Charlotte Storm Water
600 East Fourth Street
Charlotte, N C 28202-2844

Rezoning Petition Review

Rezoning Petition #: 21-018

Location of Property: Approximately 10.81 acres located in the western quadrant of the intersection of N Poplar St and West 28th St, south of Atando Ave.

SCHEMATIC SITE PLAN

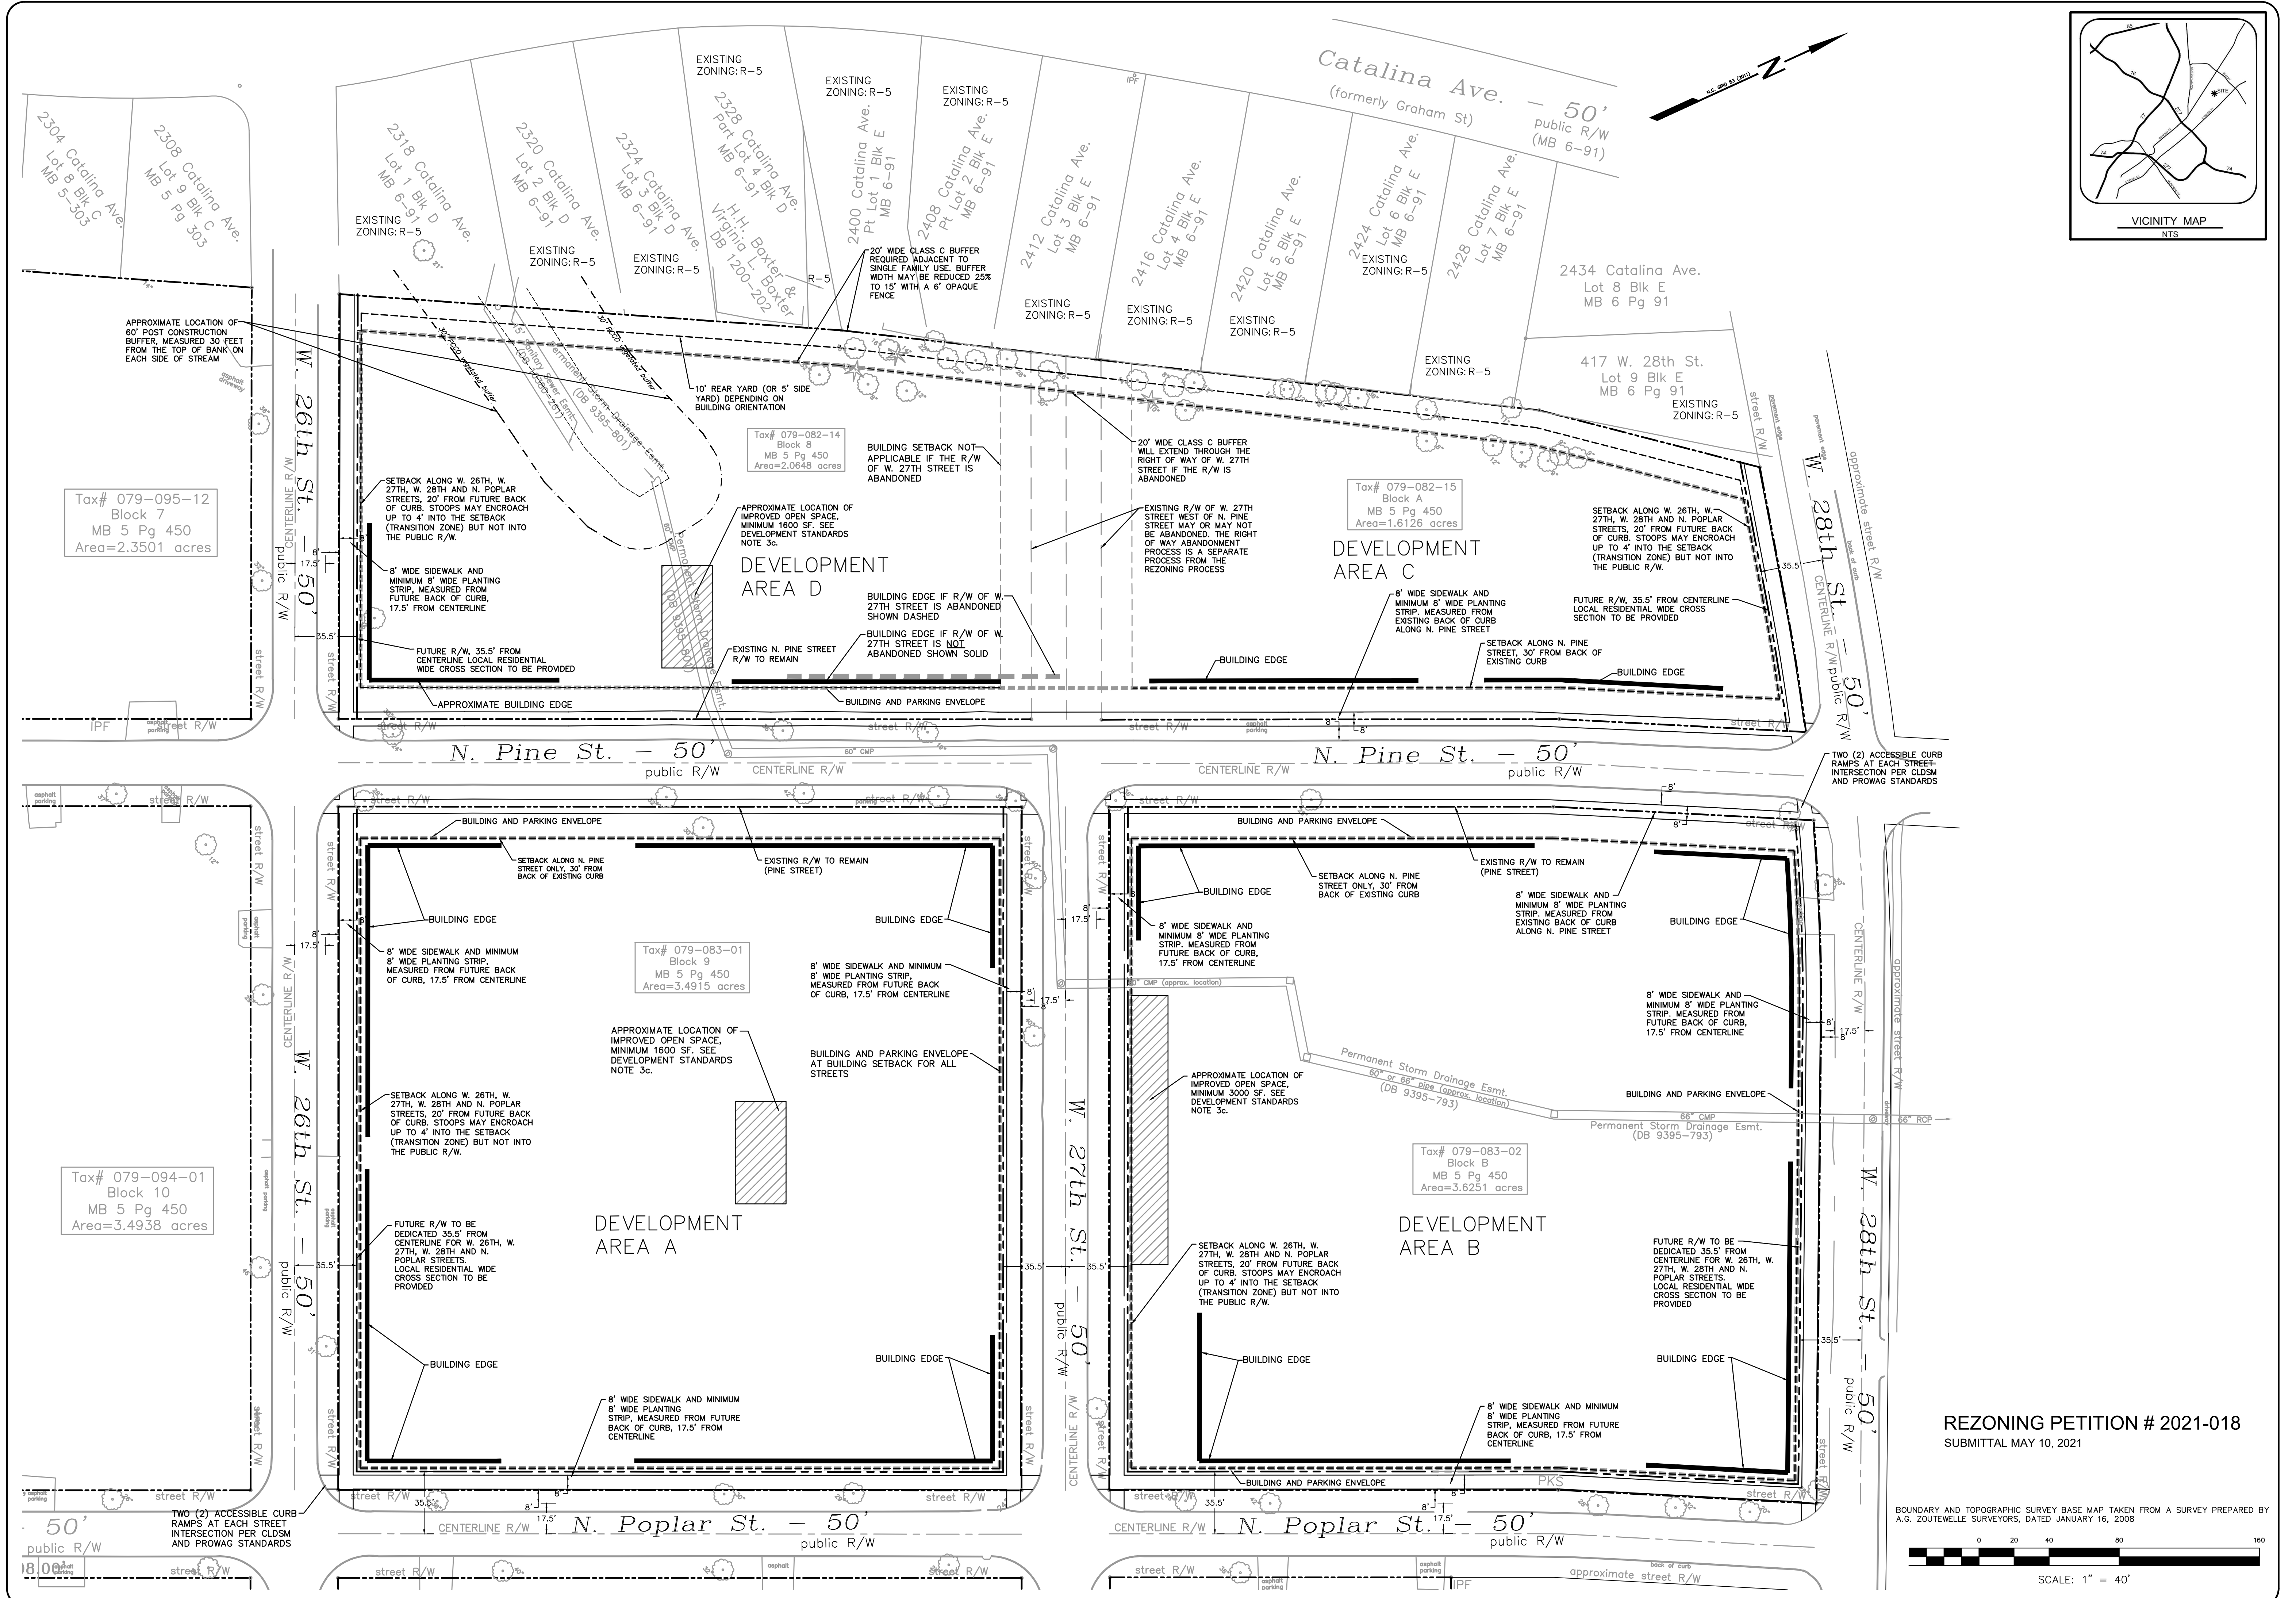
Recommendations Concerning Storm Water: City of Charlotte GIS data indicates a 30-ft PCSO buffer across the site. Please show and label *Potential 30-ft PCSO Buffer* on the site plan. Any increase of impervious area within such buffers may not be allowed and is not approved with the rezoning process. Stream Delineation Reports are subject to review and approval by Charlotte Storm Water Services. Please include the following note under Environmental Features: *“Development within any SWIM/PCSO Buffer shall be coordinated with and subject to approval by Charlotte-Mecklenburg Storm Water Services and mitigated if required by City ordinance. Petitioner acknowledges intermittent/perennial stream delineation reports are subject to review and approval upon submission of development plans for permitting and are not approved with rezoning decisions.”*
